10 December 2023

To: **Sally Munk**
Project Officer
NSW Dept of Planning Major Projects

Re: **Application to Modify Existing Commercial Aquaculture Development (Relocation and Expansion)**
Jervis Bay NSW
SSI-5657-Mod-1

Figure 1: Approximate location of the Lease areas (SSI-5657-Mod-1)

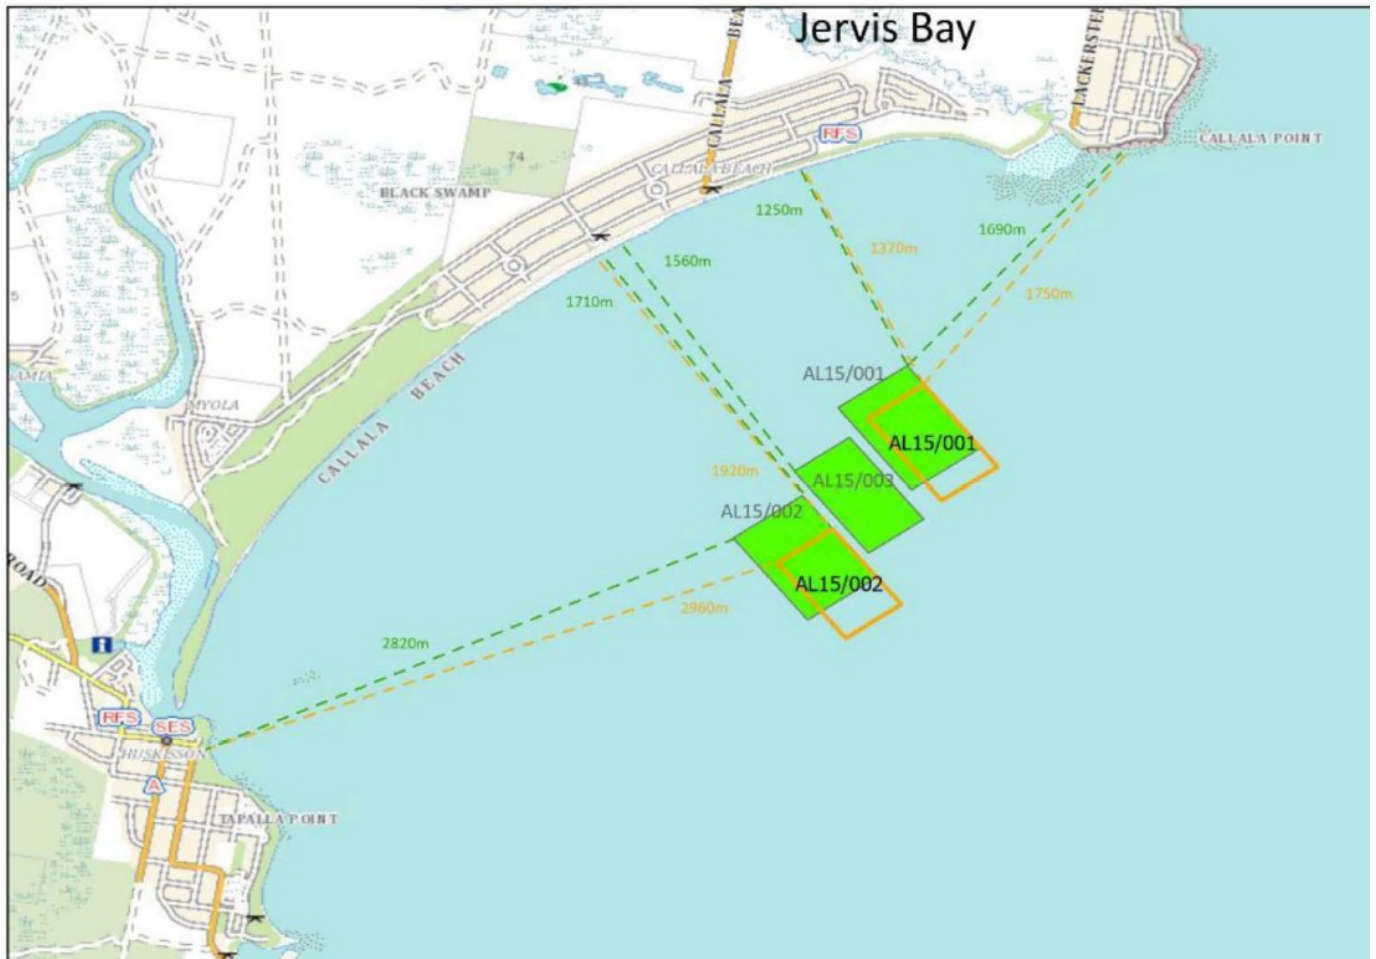
- the highly impactful existing leases of 40Ha in front of Callala Beach are proposed to be increased to 70Ha: **a 75% increase in area.**
- A new, third lease area is proposed to be constructed between the two existing leases, thereby occupying the entire view corridor from all Callala Beach public access points to the iconic Jervis Bay Heads.

- existing expanded and new leases are proposed to be moved up to 250m closer to Callala Beach.
- it has not been made clear why this is necessary, however DPI have stated this is due to *"an error in Callala Beach lease co-ordinates made when maps were digitised in 2013"*, which has resulted in an encroachment on the *Naval Trace Line*.

- this is proposed to be achieved by attaching an additional 10Ha to the landward side of each existing lease, resulting in permanent closer proximity to Callala Beach and therefore significantly increased visual impacts.

- NO CHANGE TO EXISTING AQUACULTURE FOOTPRINT IN FRONT OF CALLALA BEACH.
- NO PART OF ANY LEASE TO BE MOVED CLOSER TO CALLALA BEACH THAN CURRENT POSITION.
- VINCENTIA SITE LOCATION BE EITHER RETAINED OR RELOCATED TO AN ALTERNATIVE LOCATION (NOT CALLALA).
- INITIATE IMMEDIATE STATE GOVT INTERVENTION TO DIRECT NAVY ADJUSTMENT OF THE NAVAL TRACE LINE IN ORDER TO RETAIN EXISTING CALLALA BEACH LEASE LOCATIONS. (Noting that the Callala Beach leases are at the outer perimeter of the Naval Trace Line, many other areas within Jervis Bay outside the trace line are closer to the Beecroft Peninsula and naval operations).
- FURTHER INVESTIGATE ENTIRE RELOCATION OF LEASES TO MORE APPROPRIATE AND LESS IMPACTFUL SITE/S.
- EXTEND ADVERTISING PERIOD TO END JANUARY MINIMUM, SUPPORTED BY MEDIA EXPOSURE+LETTER BOX DROPS.
